**WEST SUSSEX COUNTY COUNCIL
INFRASTRUCTURE CONSULTATION**

SUBJECT: LU/189/10-Erection of 2no. lamp posts with lights to replace existing pavement lights.

East Beach Cafe, The Promenade, Sea Road, Littlehampton, West Sussex, BN17 5GB

LIGHTING AT
EAST BEACH CAFE
THE PROMENADE
SEA ROAD,
LITTLEHAMPTON, BN17 5GB.

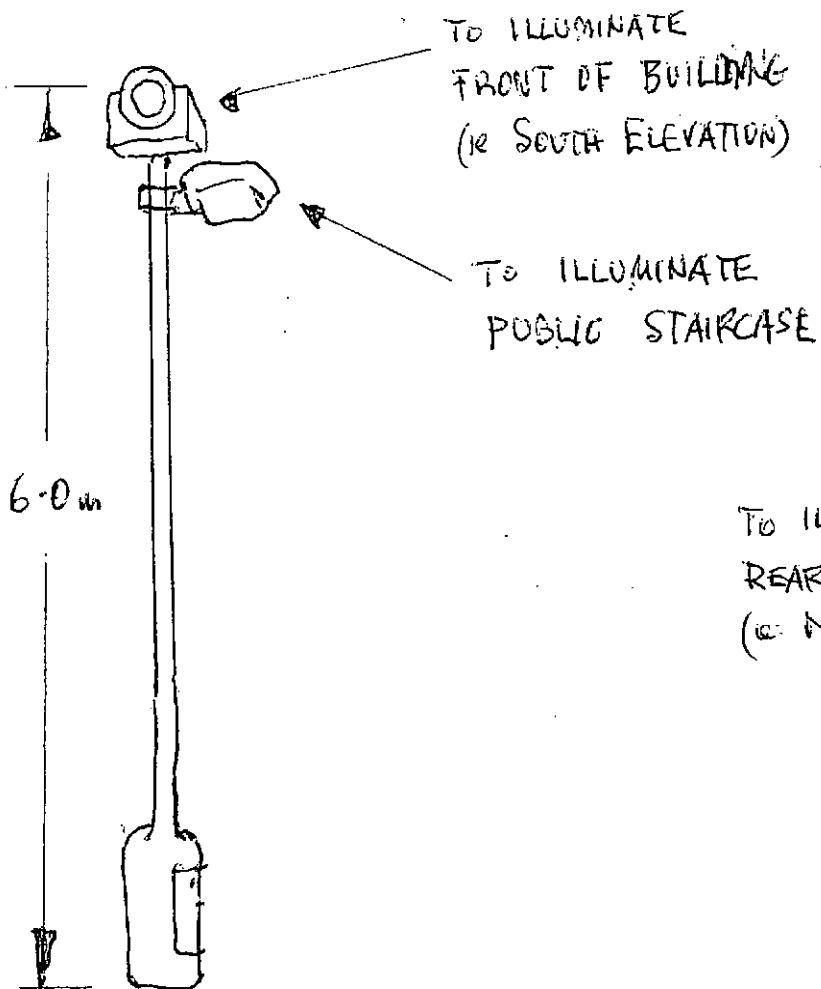
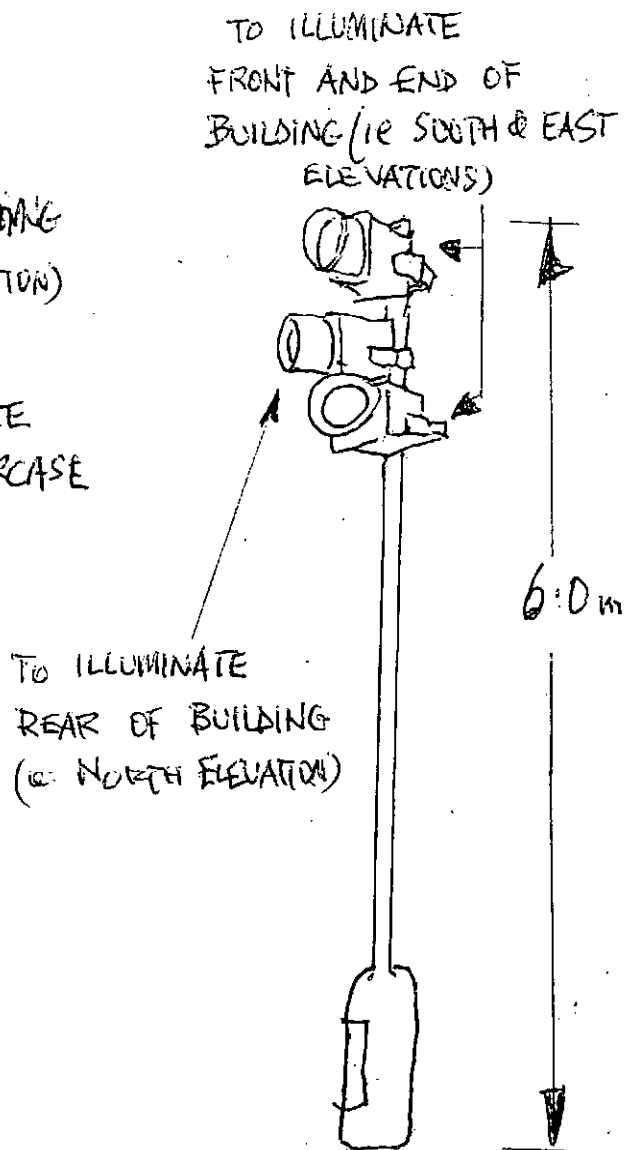
The proposal and its particulars are described above. There would be no concerns with the positioning of these two pavement lights; an area office licence will be required nonetheless.

The applicant is advised to contact the Area Engineer, West Sussex County Council, Drayton Lane, Drayton, Chichester, PO20 6BW, (Tel no: 01243 836900) to obtain formal approval from the highway authority to carry out the site access works on the public highway.
